## REQUEST

Current Zoning: MX-2 (mixed use district) with 5-year vested rights  
Proposed Zoning: I-2(CD) (general industrial, conditional) & MX-2 (mixed use district)

The petition proposes to allow a maximum 2.5 million square foot data center and an electric substation on acreage located at the southeast quadrant of University City Boulevard and Interstate 485 in northeast Charlotte.

Staff recommends approval of this petition.

RZ-1.0

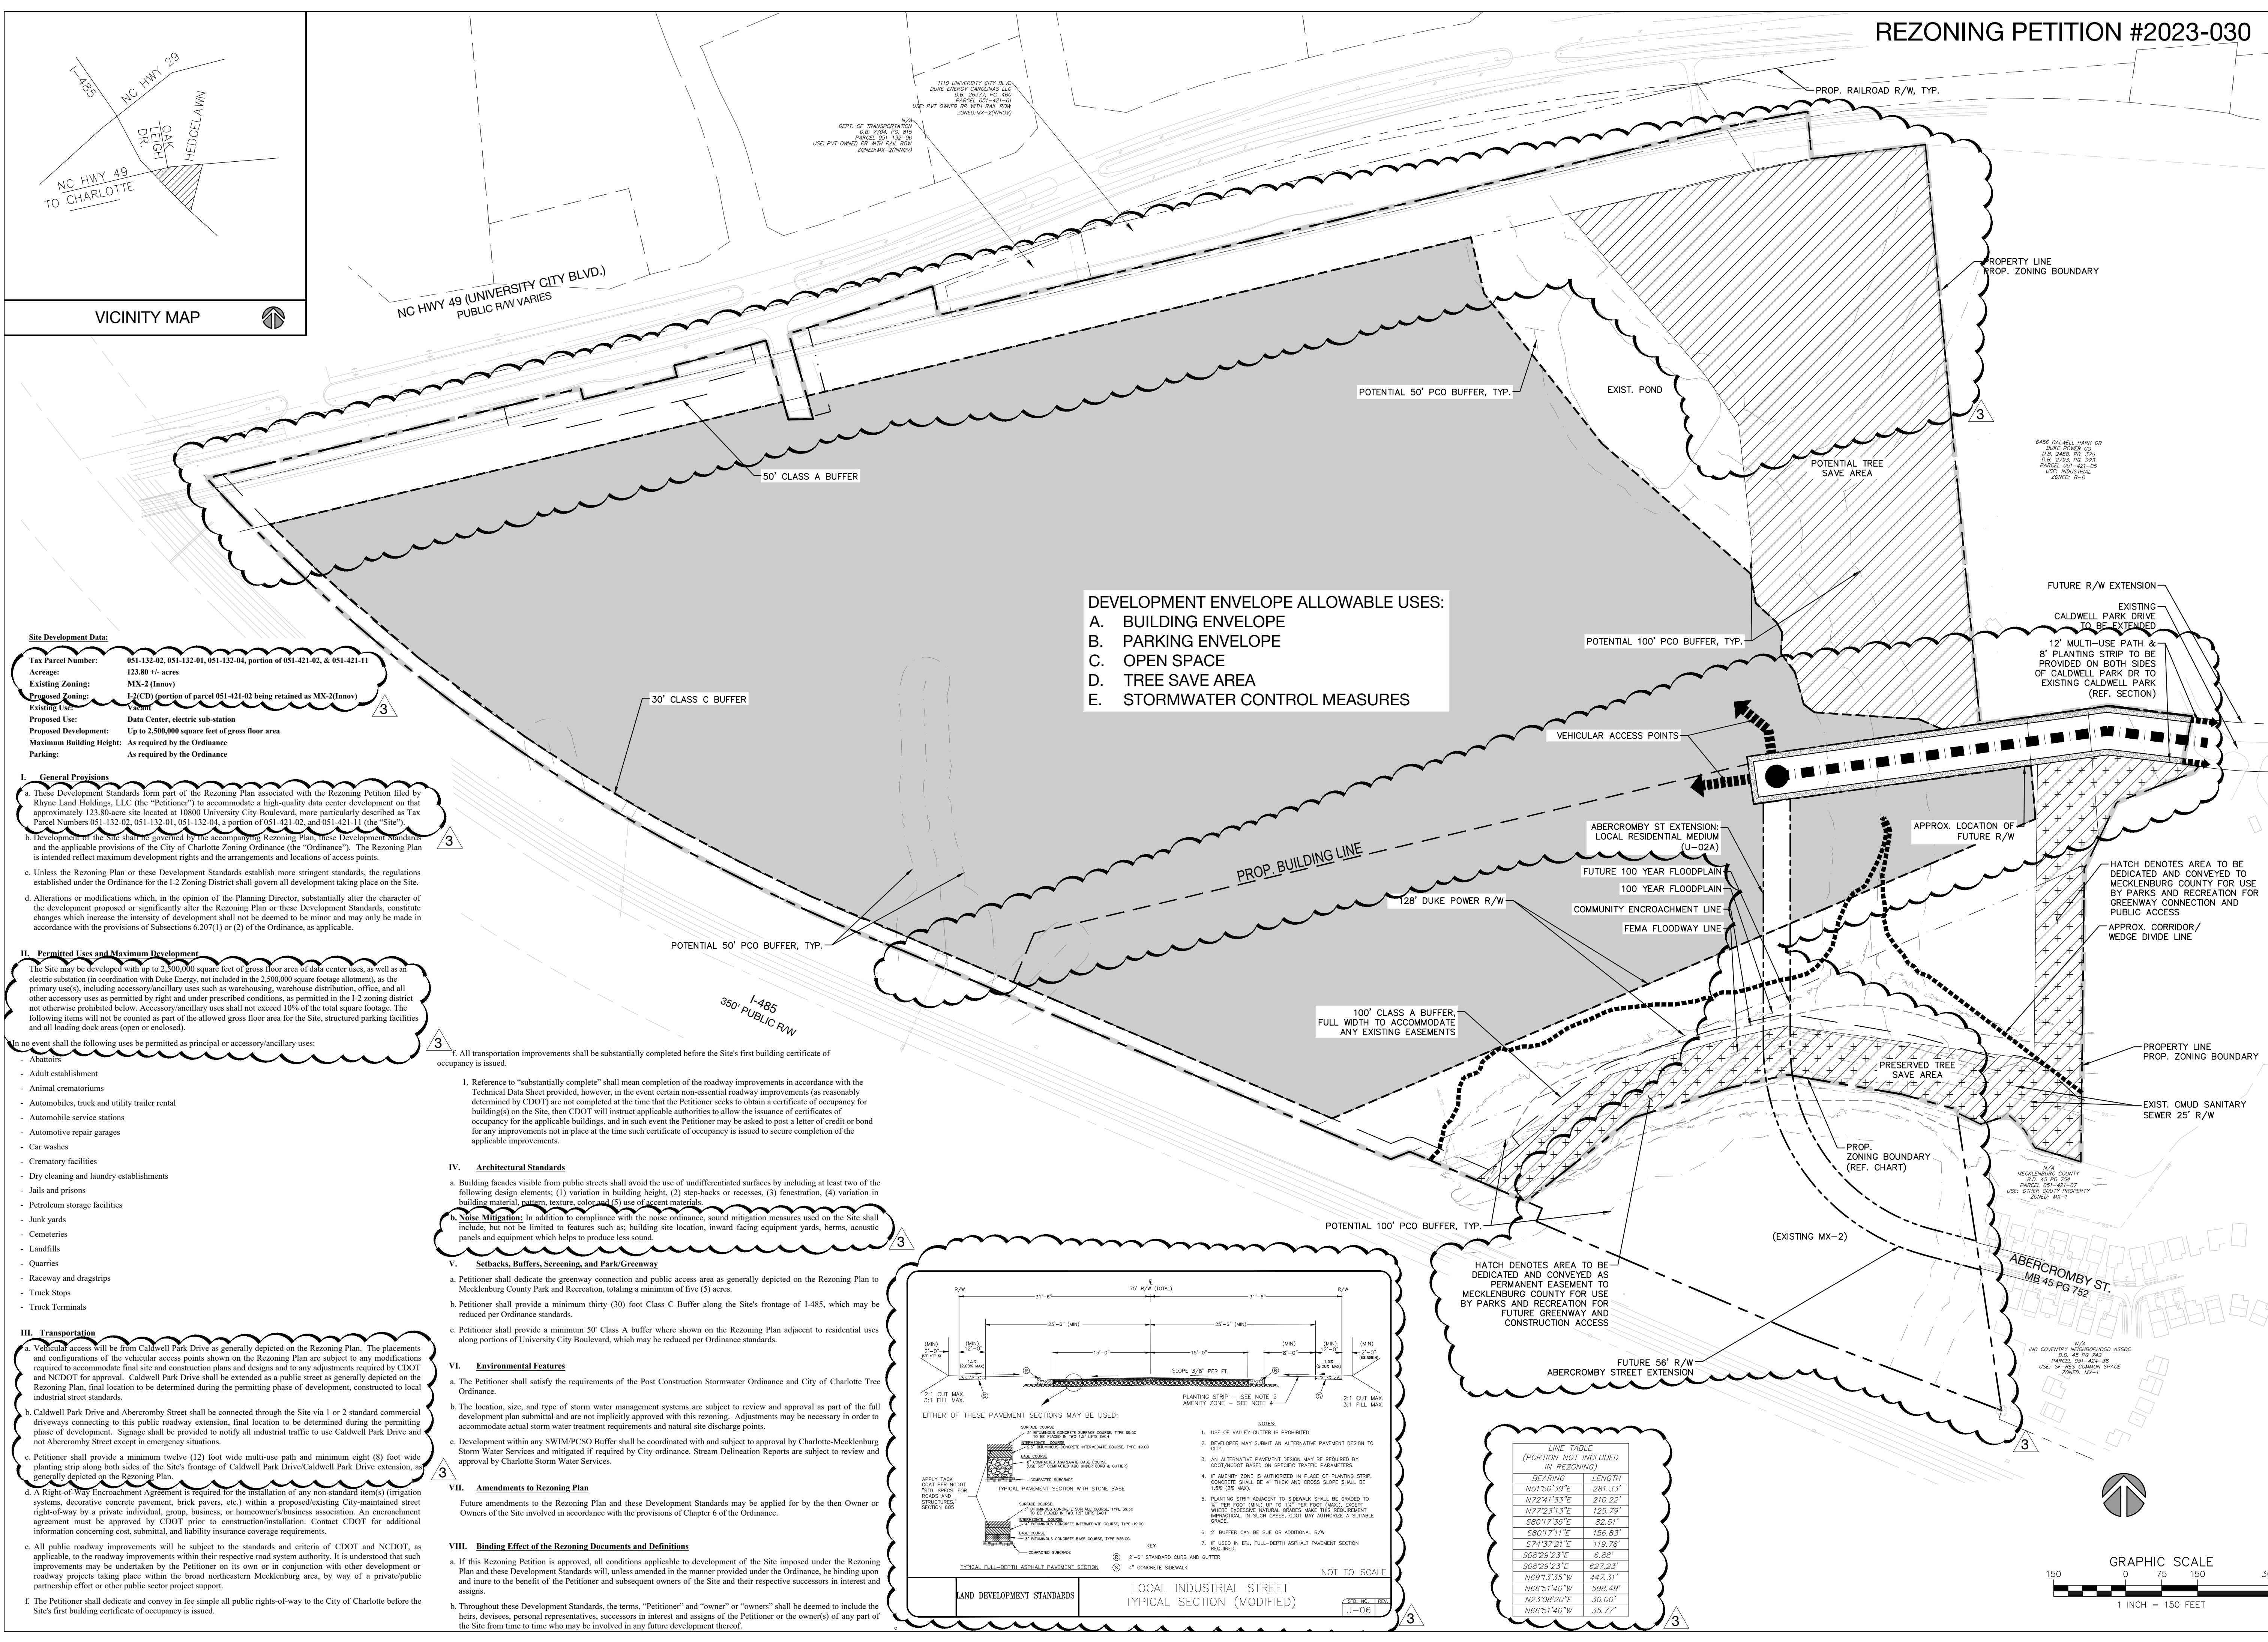
- ~~1. Revise site plan and conditional notes to connect Abercromby Street to Caldwell Park Drive. Site access shall be via 1 or 2 standard commercial driveways connecting to this roadway extension. Site plan shall commit to installing signage for all industrial traffic to use Caldwell Park Drive and not Abercromby Street.~~

2. ~~Add conditional note that petitioner shall construct bicycle facilities by installing a 12' multi-use path with an 8' minimum planting strip along Caldwell Park Drive. The proposed multiuse path should be extended along the southern side of Caldwell Park Drive to the northwest corner of Parcel ID 05114117 owned by Mecklenburg County.~~

**Clarifying Comment 6.21.2023:** ~~Label and dimension streetscape elements (12' multi-used path and 8' planting strip) along Caldwell Park Drive/Caldwell Park Drive extension.~~

**Clarifying Comment 7.28.2023:** ~~12-foot multi-use path shall be placed on both sides of the Caldwell Park Drive extension.~~

3. ~~Provide a more defined location of buildings proposed on the site, particularly those adjacent to the single family residential uses to the south. Illustrates a proposed building line.~~
4. ~~Provide a berm as part of the 100' buffer to provide additional separation and screening from single family residential uses to the south. Petitioner Response: A berm would require trees to be removed and may cause more harm than good. Per discussions with staff, the petitioner removed the word "potential" from tree save, so this will be tree save area and no berm is necessary.~~
5. ~~Provide clarification on any proposed mitigation for sound impacts associated with the data center use. Language pertaining to noise mitigation has been added to the language.~~

- Illustrates a proposed building line on the site plan.
- Proposes vehicular access from Caldwell Park Drive, to be constructed to local industrial standards. Notes Caldwell Park Drive and Abercromby Street shall be connected through site via 1 or 2 standard commercial driveways connecting to this public roadway extension, final location to be determined during the permitting phase of development. Signage shall be provided to notify all industrial traffic to use Caldwell Park Drive and not Abercromby Street except in emergency situations.

- Provides a minimum 12-foot wide multi-use path and minimum eight-foot planting strip ~~along the site's frontage~~ both sides of Caldwell Park Drive/Caldwell Park Drive extension.

- Removes building envelope at the northeast corner of site and replaces with tree save. Removes reference to tree save from proposed Class A buffer along University City Boulevard.

- Notes in addition to compliance with the noise ordinance, sound mitigation measures used on the site shall include, but not be limited to features such as; building site location, inward facing equipment yards, berms, acoustic panels and equipment which helps to produce less sound.
